MONA OFFSHORE WIND PROJECT

Annex 3.10 to the Applicant's response to Relevant Representations at the Procedural Deadline

Applicant's Response to Relevant Representation from Natural Resources Wales (NRW): RR-011.138

Document Number: MOCNS-J3303-RPS-10231

Figure 1.3: Surface watercourses and NRW flood zones within the Mona hydrology and flood risk study area (sheet 1).

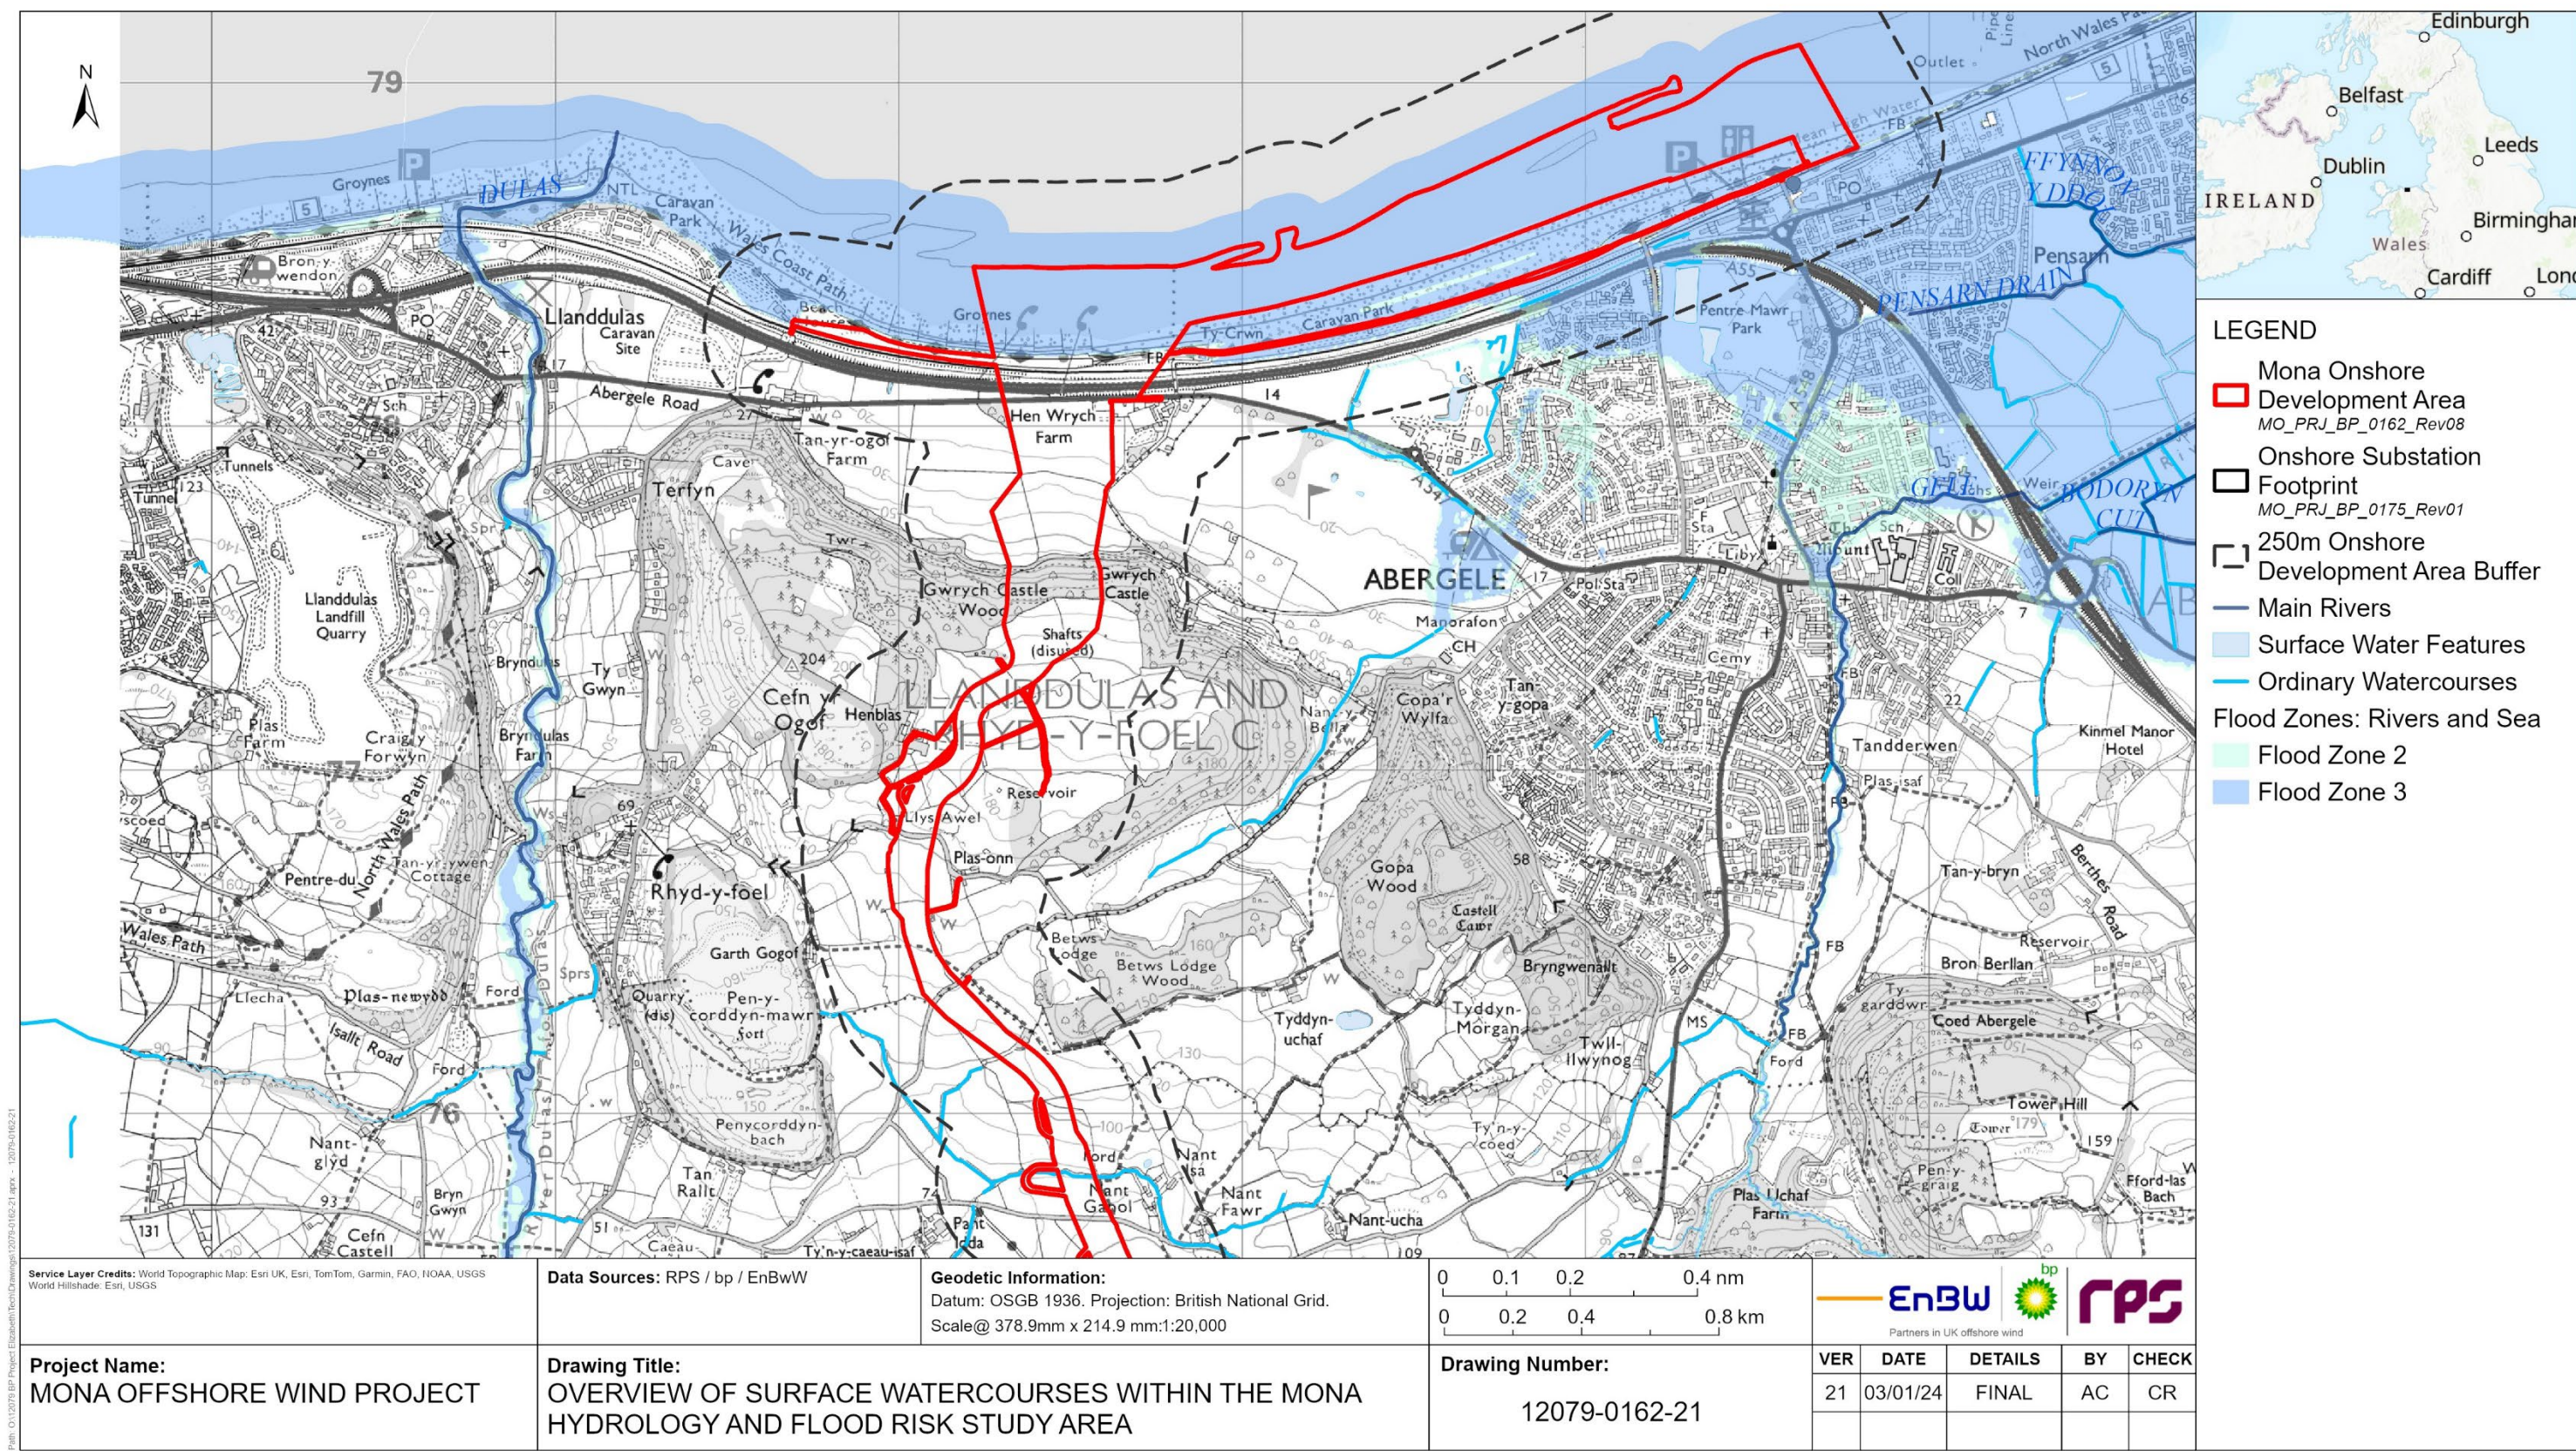
1.1.1.3 *Para 3.6.3.1. The title of the document may be misleading by using 'Surface watercourses...'. There are no references to the mapped outlines for Surface Water and Small Watercourses as shown on the Flood Map for Planning for watercourses which have a catchment area less than 3km². This is crucial since all of crossings along the route are those of small (ordinary) watercourses and the document should be updated accordingly.*

1.1.1.4 *Para 3.6.3.2. It is noted that 'ordinary' watercourses have been shown on figures 1.3 to 1.5 along with Main Rivers. It may therefore be useful to use the FMfP 'detailed view' to produce the flood outlines for Sea, for Rivers and for Surface Water and Small Watercourses.*

1.2.1.1 Figures 1.3 to 1.5 of Volume 7, Annex 2.2: Surface watercourses and NRW Flood Zones (APP-118) have been updated to include the mapped outlines for Surface Water and Small Watercourses as shown on the Flood Map for Planning.
